**From:** [Roy Warren](#)  
**To:** [Planning](#)  
**Cc:** [David Elmore](#)  
**Subject:** App Ref: 6/2019/0085/FULL - Chancellors School, Pine Grove, Brookmans Park, Hatfield, AL9 7BN  
**Date:** 05 March 2019 17:16:44

**App Ref: 6/2019/0085/FULL - Chancellors School, Pine Grove, Brookmans Park, Hatfield, AL9 7BN (Sport England Ref: PA/18/E/WH/51286)**

## **COMMENTS MADE AS A NON-STATUTORY CONSULTEE**

building + drawing title  
**Sports Hall & Teaching Block  
Ground and First Floor Plans**

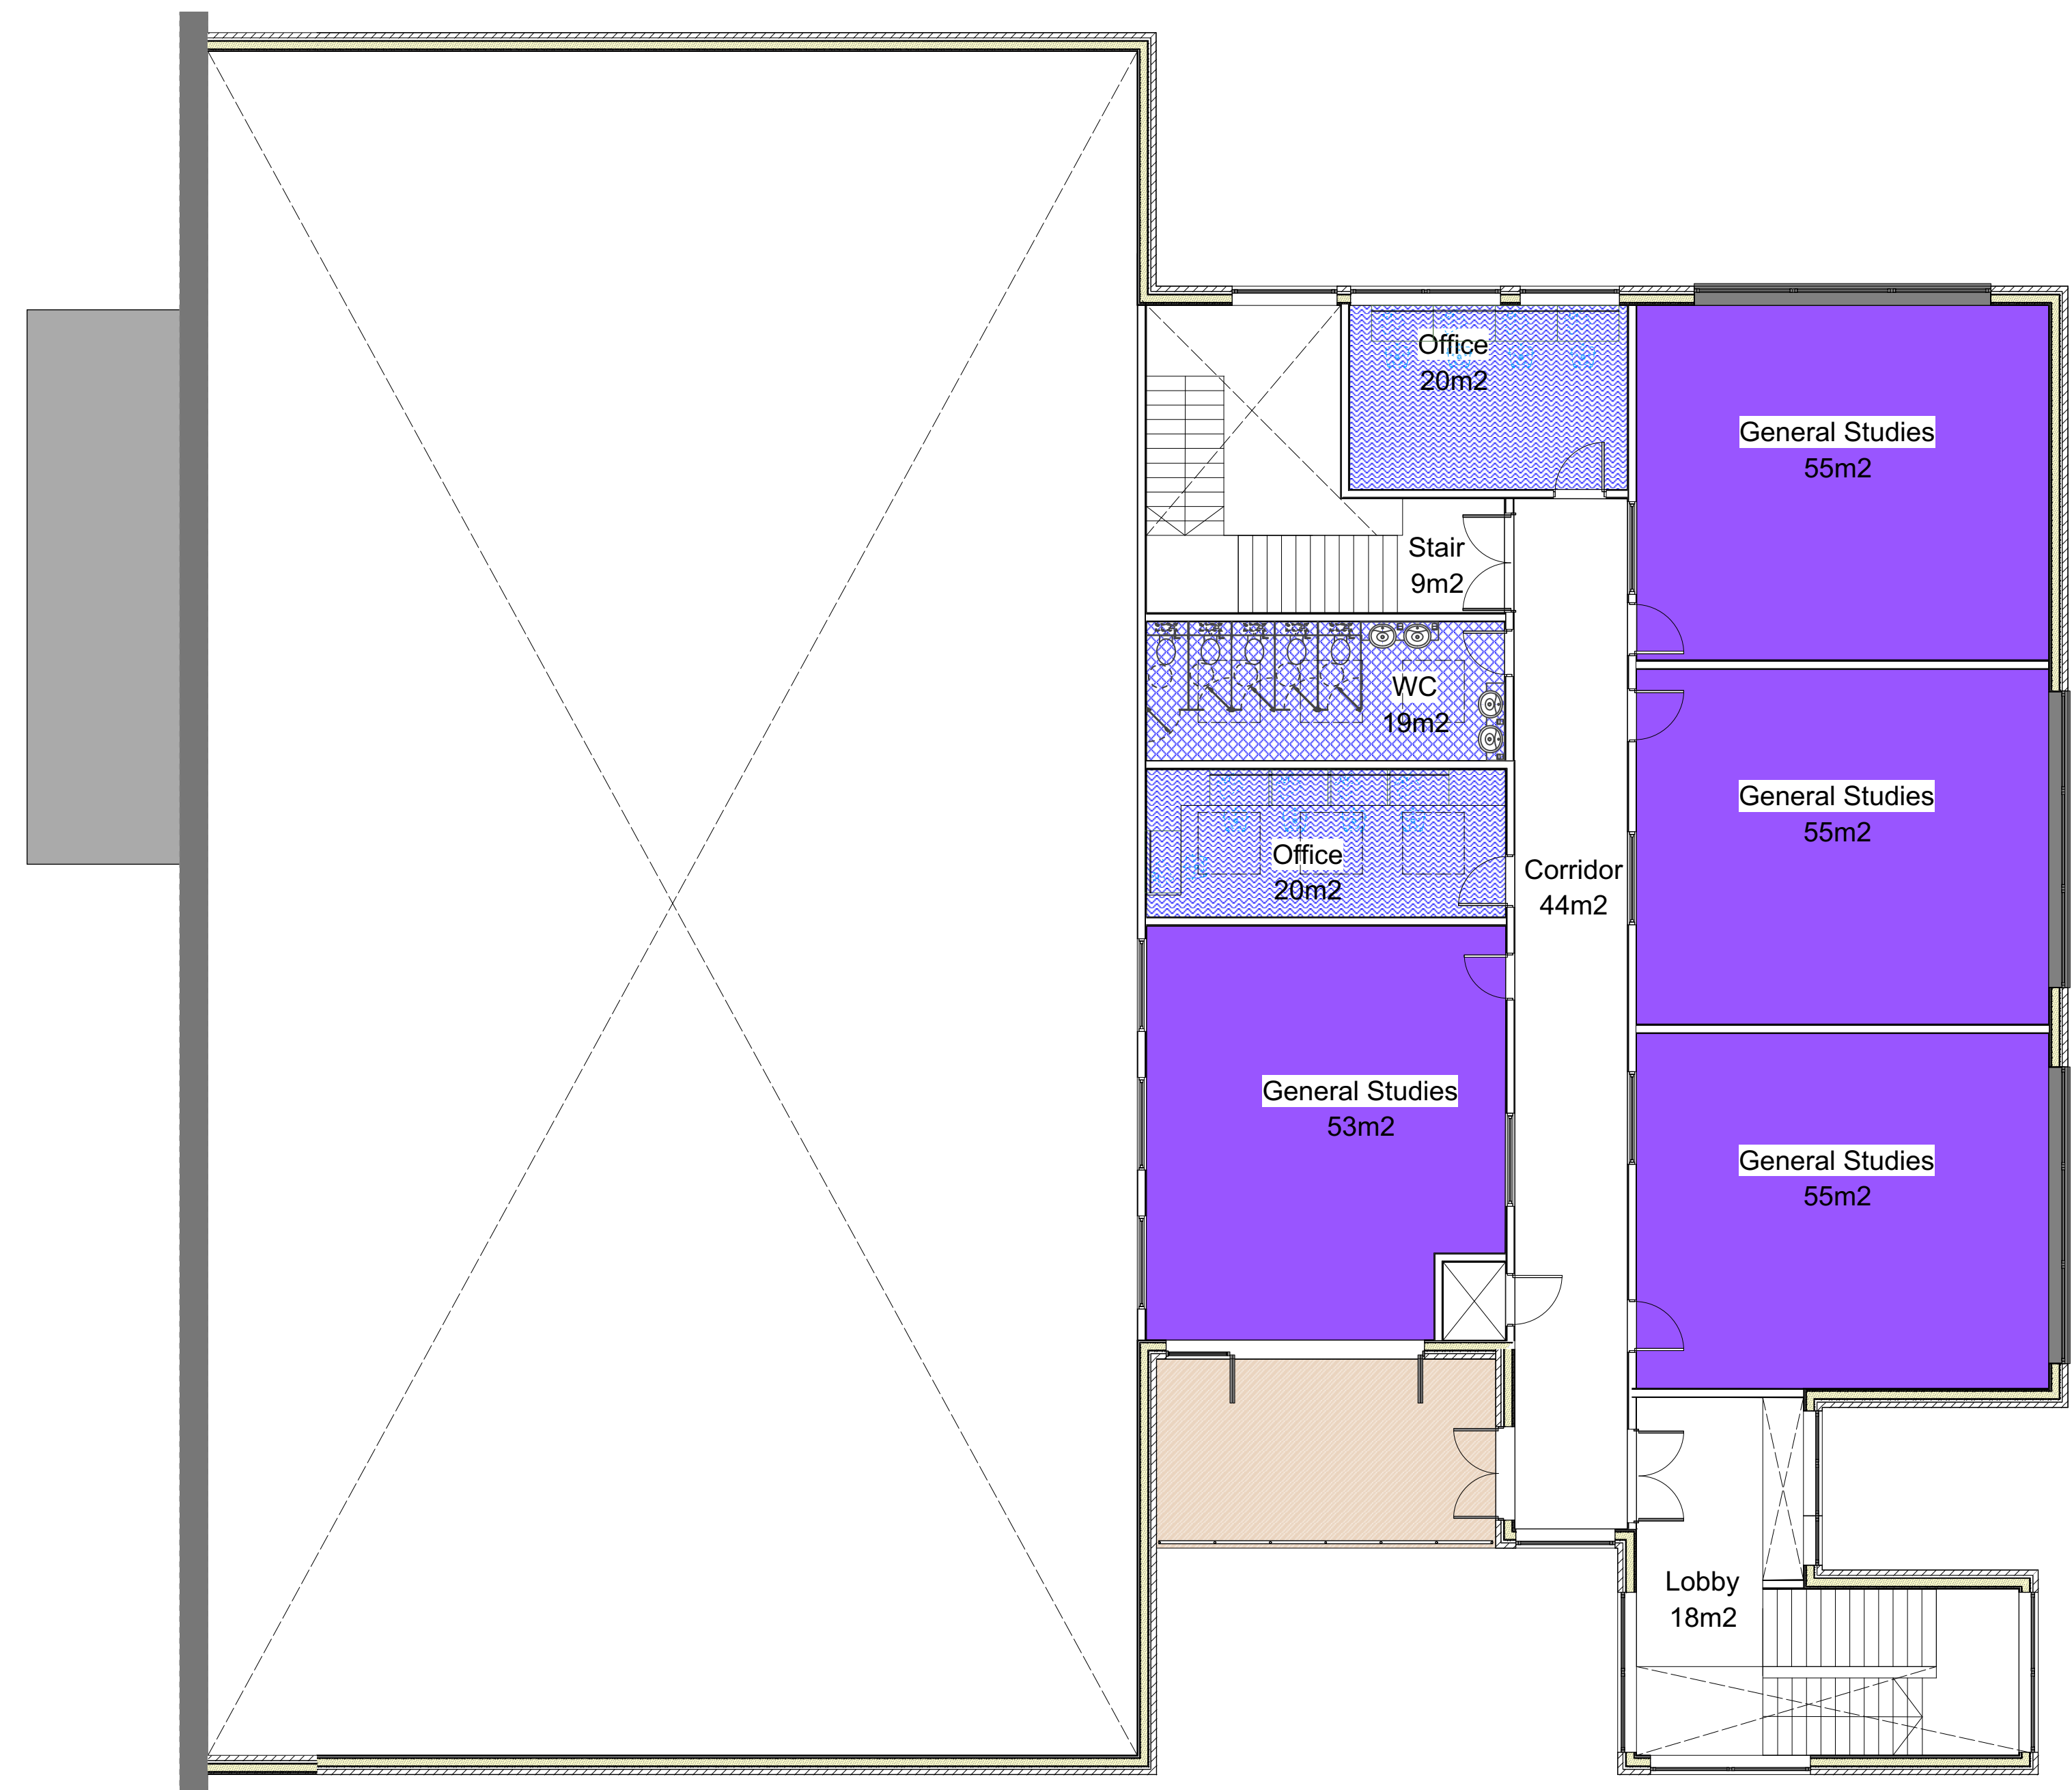
- Draught lobby – Sport England recommend a draught lobby on sites that will have regular community use. Without a draught lobby the reception area (where the office is proposed) is likely to have significant highs and lows in temperature.

- No reception point – while there is a foyer and a circulation area, there is no drop level reception point which would be expected for facilitating community use.

- The lack of viewing area from outside the hall is also likely to be an issue for both school and community users. For both school and community use having an ability to have a viewing area into the hall from the reception/foyer is likely to be an important factor.

- If the external decking area and one of the classrooms on the first floor is to be used for social events, consideration should be given to providing a small kitchen facility to serve refreshments on the ground floor as it is unclear how the building will support social events without a kitchen facility.

- A single point of internal entry in to the hall space is not recommended as this would not allow separate access when the hall is split 2 into two areas.

- Storage - for a facility of this size the store should be just over 74 sqm the current proposal is for 30sqm (SE recommends that storage area is equivalent to at least 12.5% of the sports hall floor area) This may cause management issues. Also, storage is preferable along both parts of the side of a sports hall to allow equipment to be moved for one part of the hall without affecting activity on the other part when it is split into a 2x2 court format. The current location of the storage one side of the hall will disrupt activity on the court area adjoining it when equipment serving the other end of the hall is moved.

- The general flow of the change area is positive and accords with our guidance.
- Vanity – more and more sites are including vanity areas to assist in encouraging participation from students.
